Application Ref:	3/2025/0823	 <p>Ribble Valley Borough Council www.ribblevalley.gov.uk</p>
Site Notice:	16/1/26	
Officer:	KH	
DELEGATED ITEM FILE REPORT:		REFUSAL

Development Description:	Proposed conversion of vacant care home (Use Class C2) 622 sq.m. into two semi-detached residential 5 bed dwellinghouses; Use of two storey annex as incidental accommodation; erection of two storey rear extension to one dwelling and erection of single storey side and rear extension to one dwelling together with dormers to front and rear elevation, first floor balconies to rear elevation, portico to front elevation, changes in fenestration and introduction of additional doors and windows to both properties and associated parking and landscaping
Site Address/Location:	Longworth House Higher Ramsgreave Road Ramsgreave BB1 9DJ

EXISTING ROOF PLAN 1:100

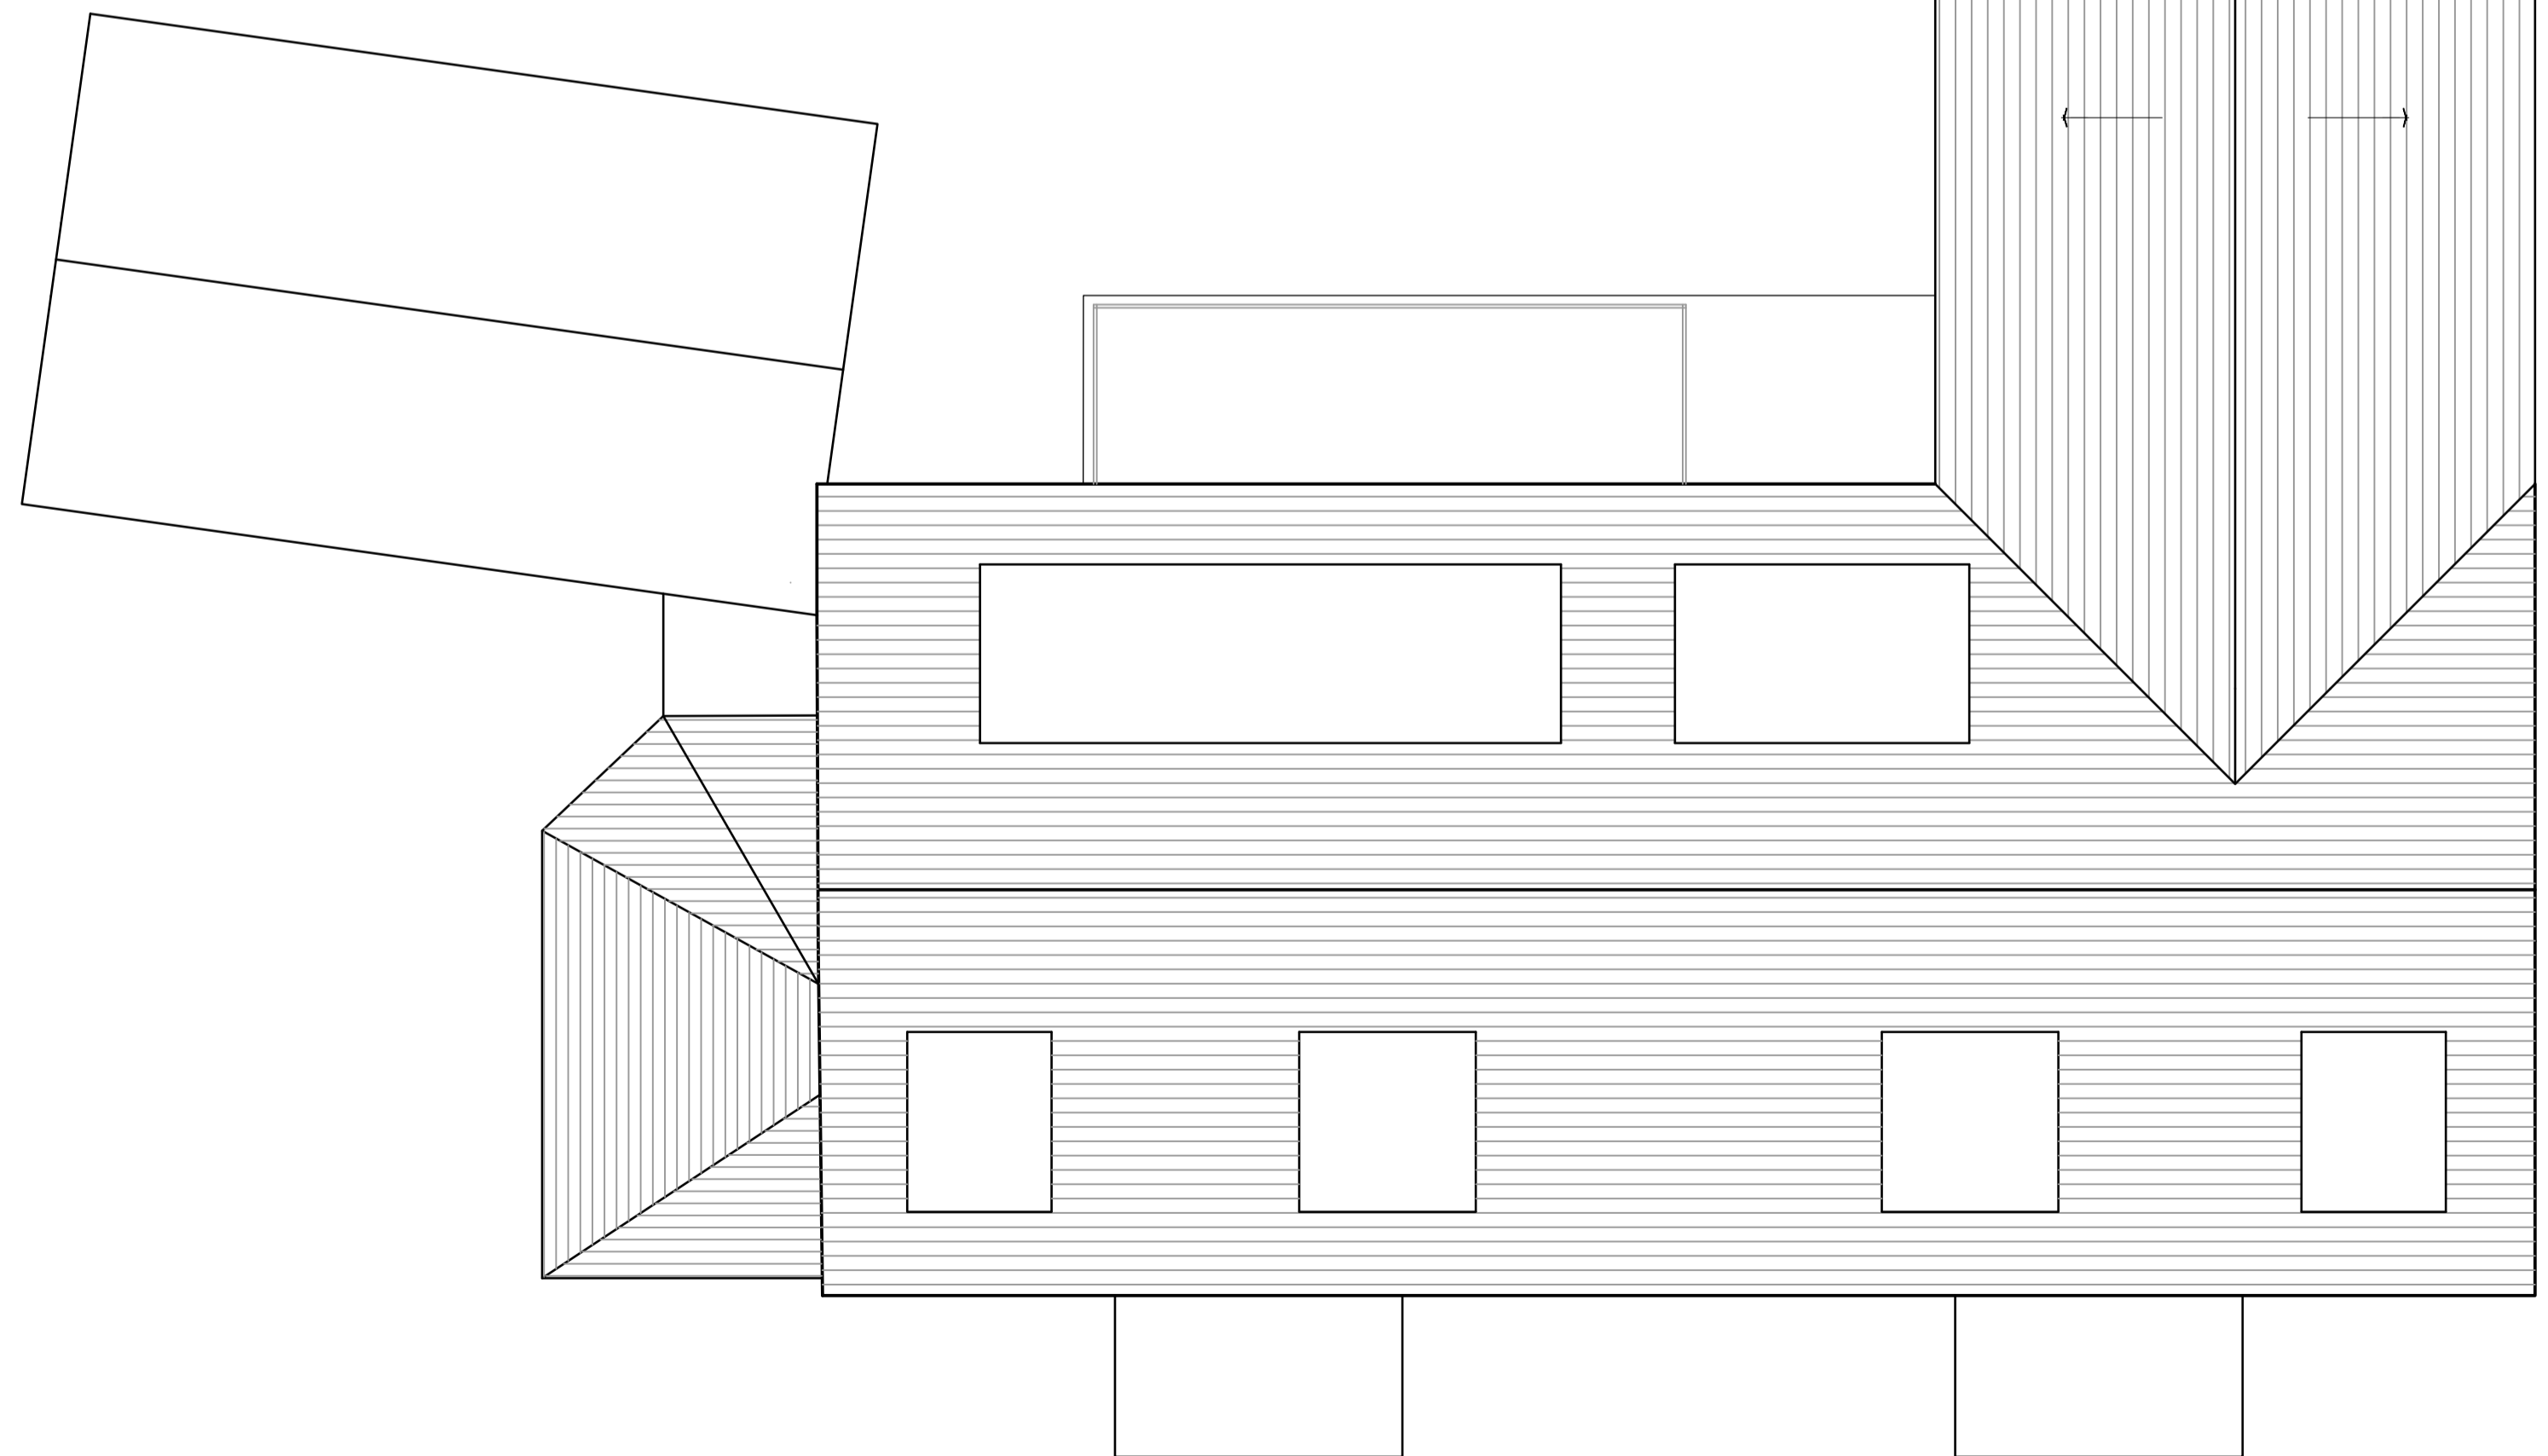
In this instance, the two storey rear gable extension, front and rear dormers, rear balcony and front porticos would read as bulky, over dominant and largely unsympathetic additions to the building which will result in a noticeable increase in the scale and massing of the structure. Accordingly, the proposal fails to satisfy the requirements of Policy DMH4.

PROPOSED FRONT ELEVATION 1:100

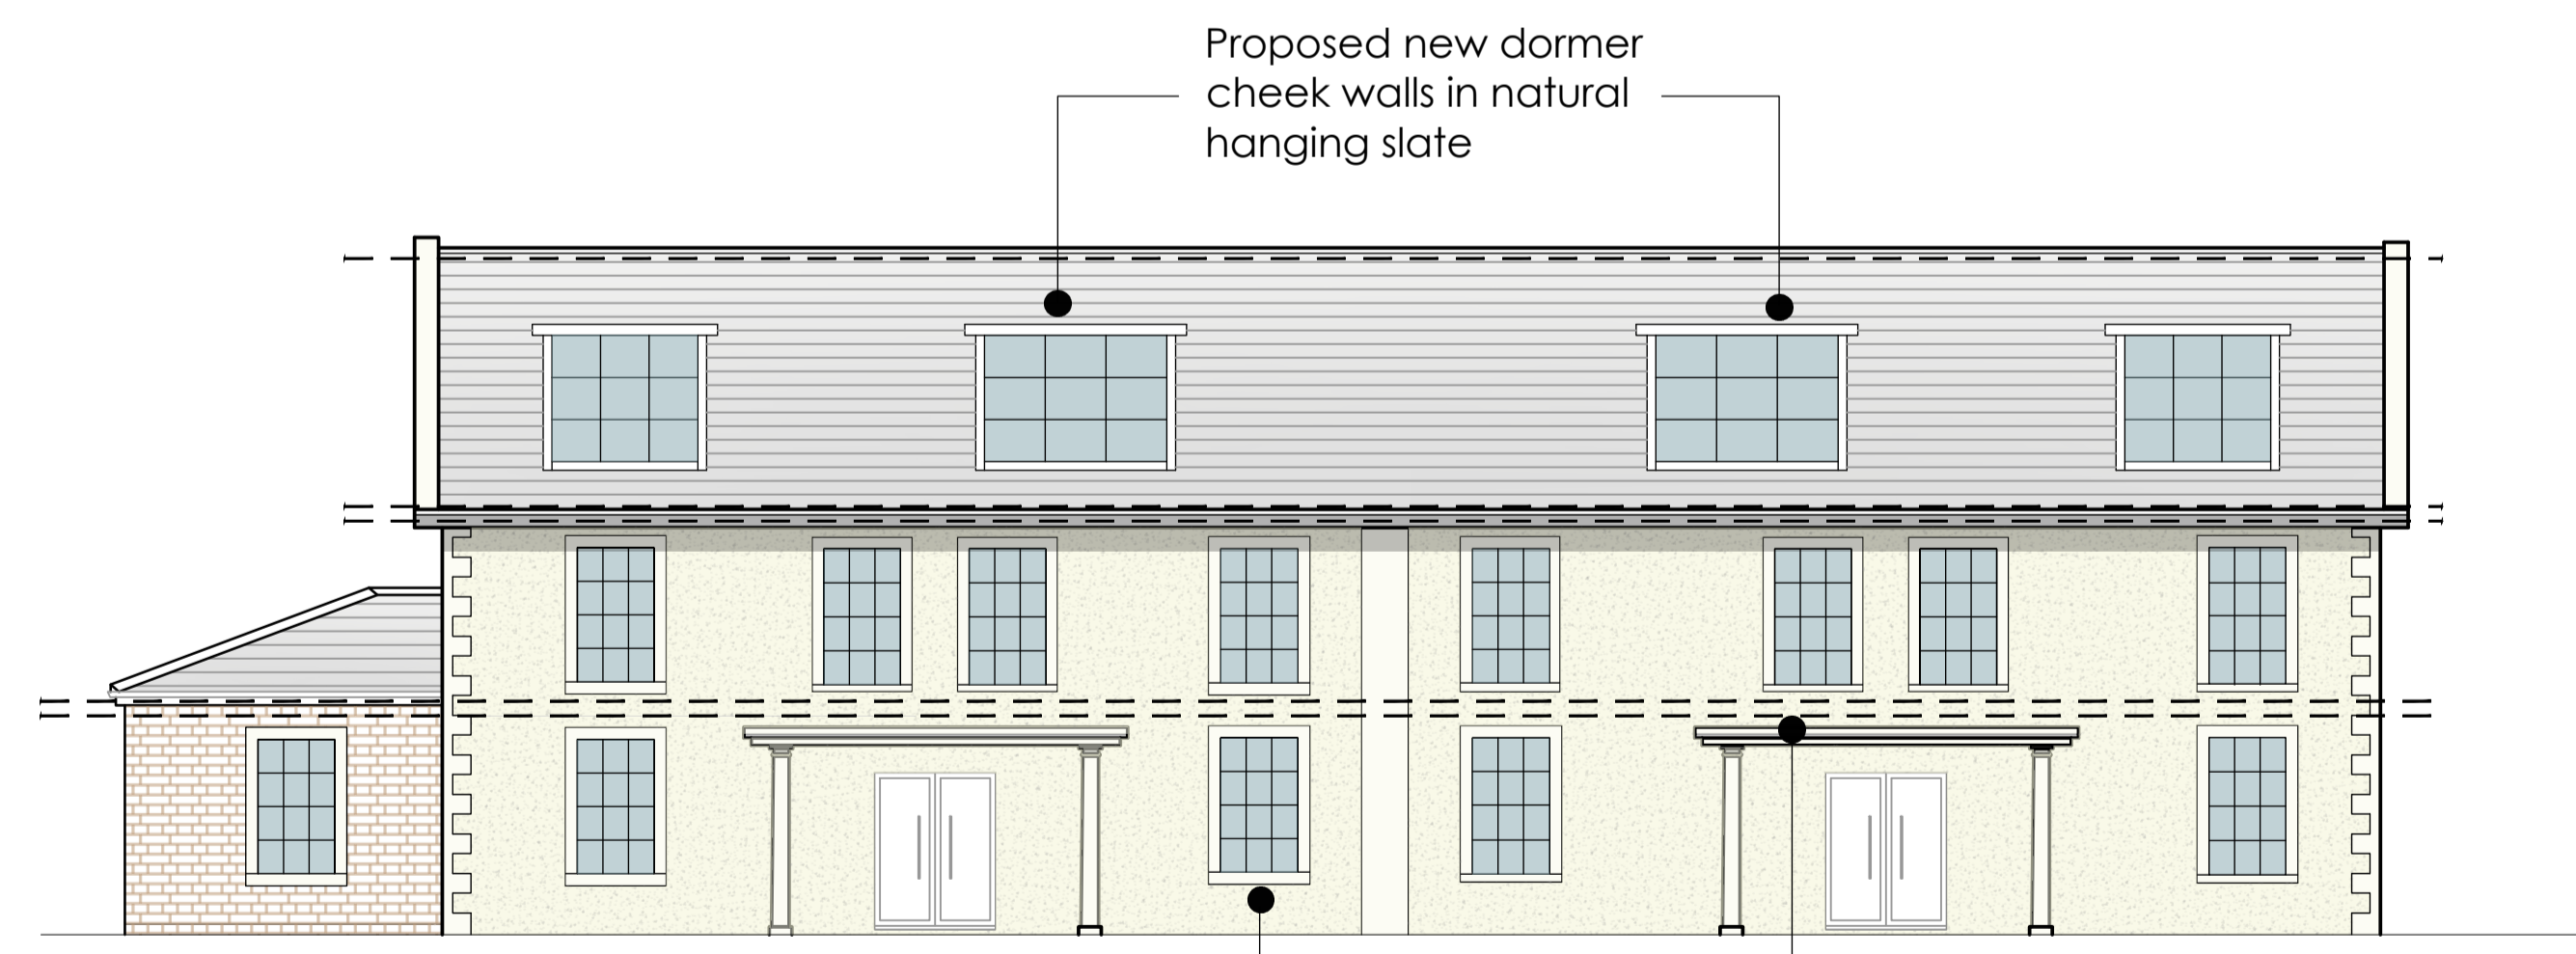
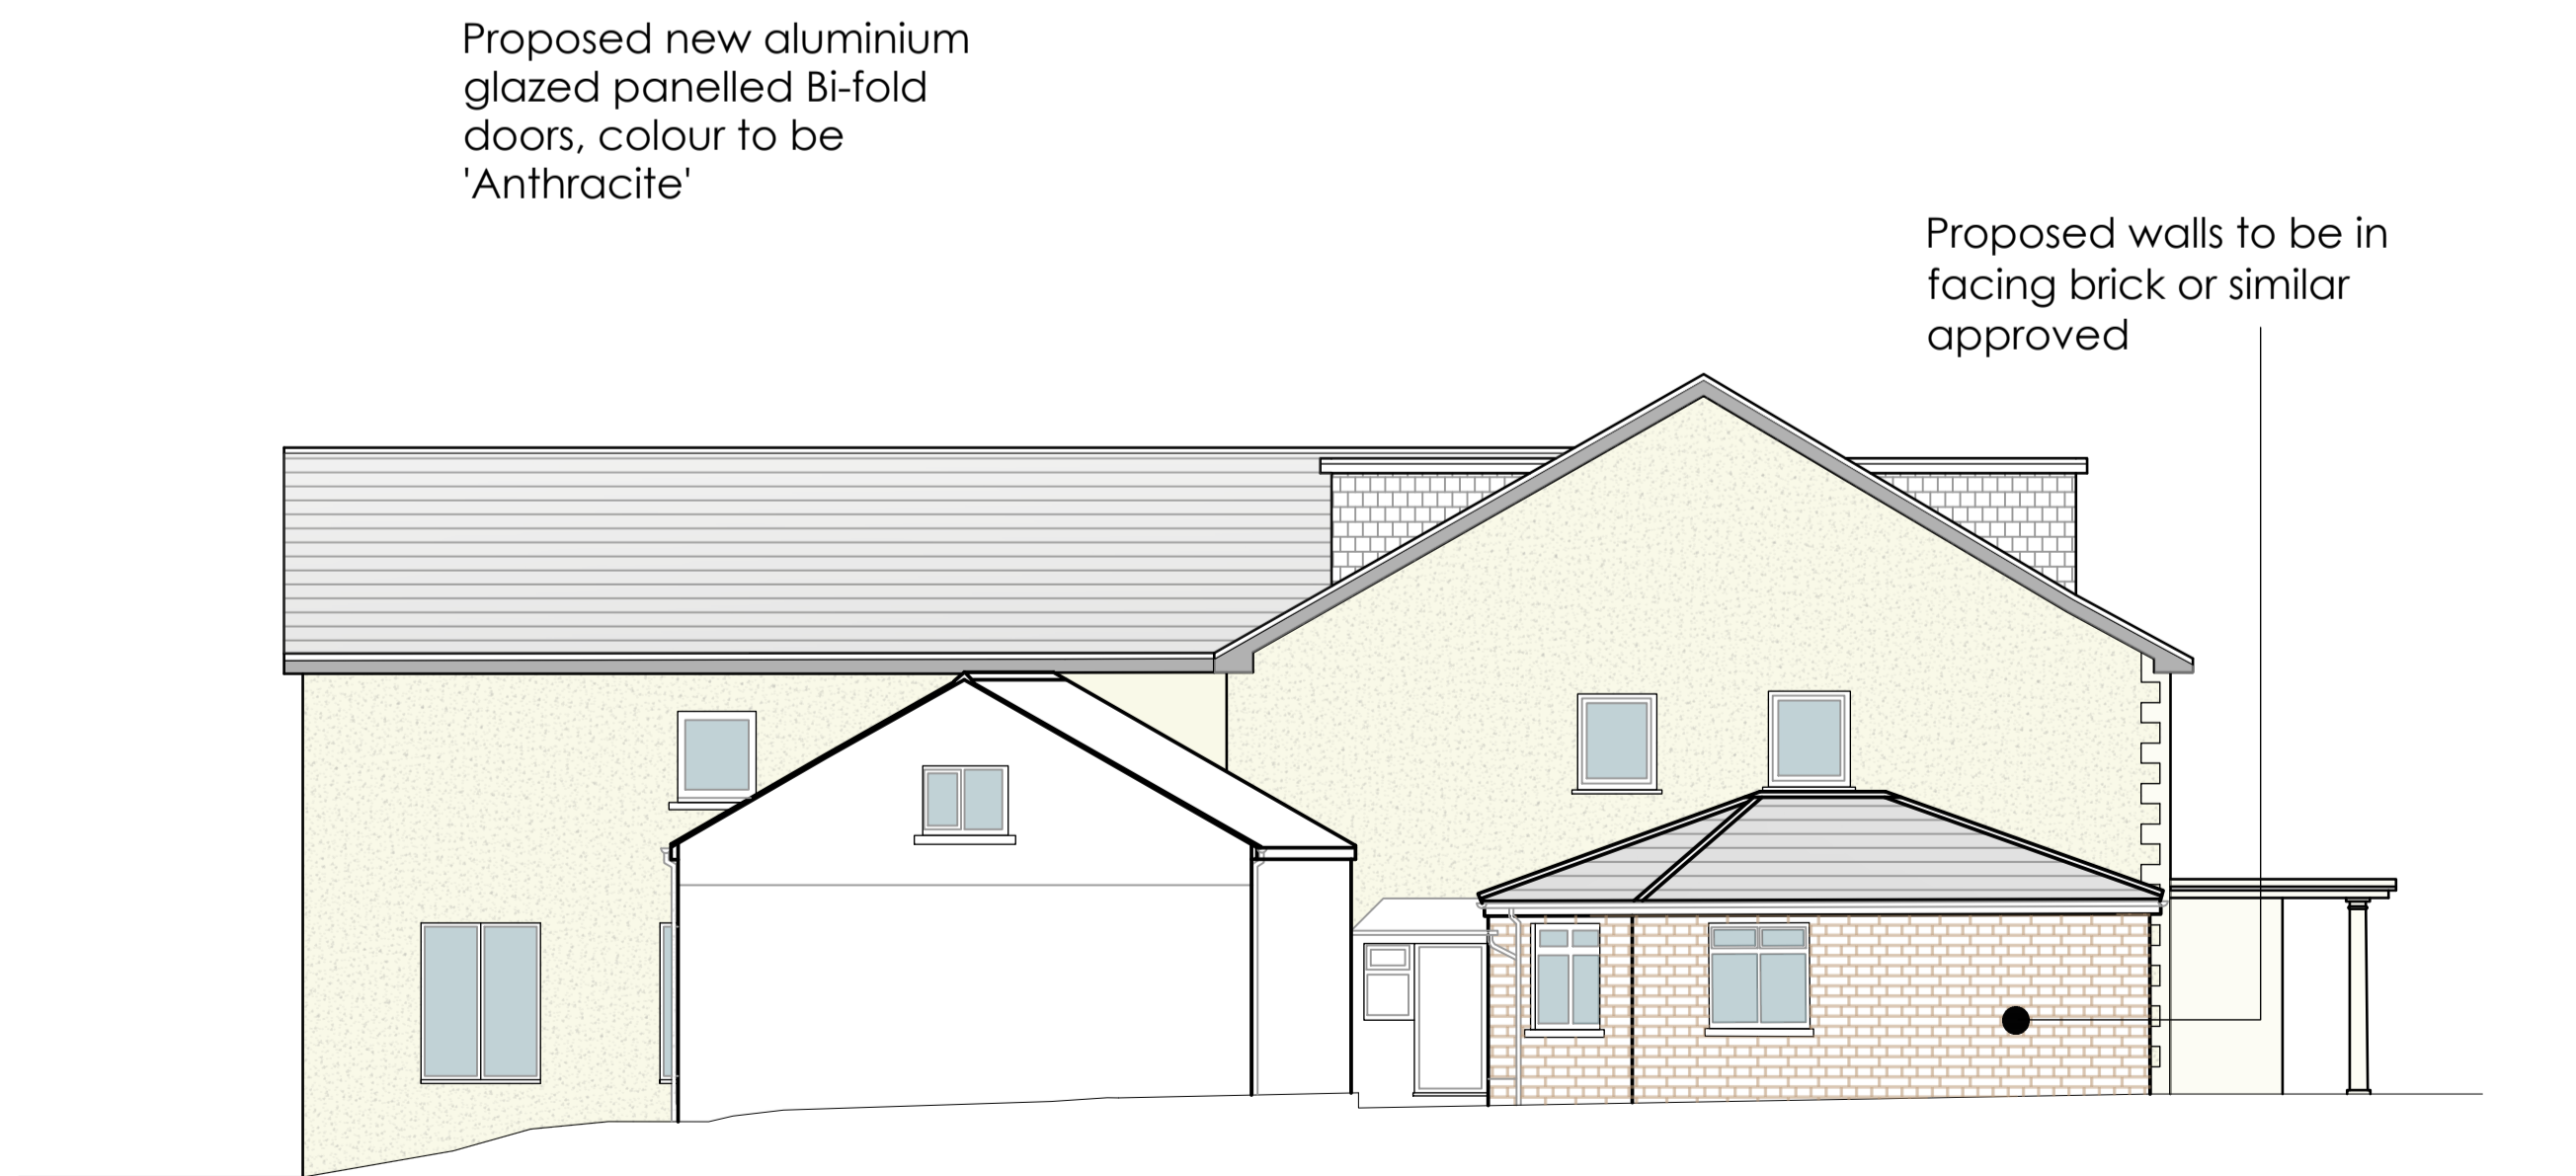
The rear balcony proposed to serve the new westerly dwelling, by virtue of its size and close proximity to the shared boundary, will result in unacceptable levels of overlooking for future occupiers of the easterly dwelling. The agent has been invited to make a number of changes to address the concerns, including pulling it away from the boundary and introducing a screen, but has asked for the application to be determined in its current form. As such the proposal will conflict with policy DMG1 of the Core Strategy by virtue of unacceptable levels of overlooking.

The proposal involves significant additions which cause concern, namely the introduction of a two-storey rear extension with rear gable and a number of dormers which read as bulky, over dominant and largely unsympathetic additions to the building which will result in a noticeable increase in its scale and massing. Furthermore the dormers do not align with the window arrangement below. Additionally, a new second floor window in the side elevation is considered to exacerbate the massing of this gable, and the rear balcony is considered to be large and out of character, as are the two new front porticos on the frontage. In respect of these, the agent has been advised to reduce the rear balcony and reduced/remove the porticos to a more appropriate design in terms of scale and height, and the double, glazed(?) entrance doors could make more of a statement as these resemble patio doors usually found to the rear/side of a

<p>01:</p>	<p>The proposed two storey rear gable extension, front and rear dormers, rear balcony and front porticos would read as bulky, over dominant and largely unsympathetic additions to the building. As a result they would harm the character and appearance of the building so that it would fail to be in keeping with its surroundings in terms of its form and design. Concerns are also raised in respect of the large residential curtilage proposed and the urbanising impact this would have on the countryside character. Accordingly, the proposal fails to satisfy the requirements of Policies DMG1, DMG2, DMH3 and DMH4 of the Ribble Valley Core Strategy and Paragraphs 135 and 139 of the National Planning Policy Framework.</p>
<p>02:</p>	<p>The rear balcony proposed to serve the new westerly dwelling, by virtue of its size and close proximity to the shared boundary, would result in unacceptable levels of overlooking for future occupiers of the easterly dwelling. As such the proposal would conflict with policy DMG1 of the Ribble Valley Core Strategy by virtue of unacceptable impacts on residential amenity.</p>
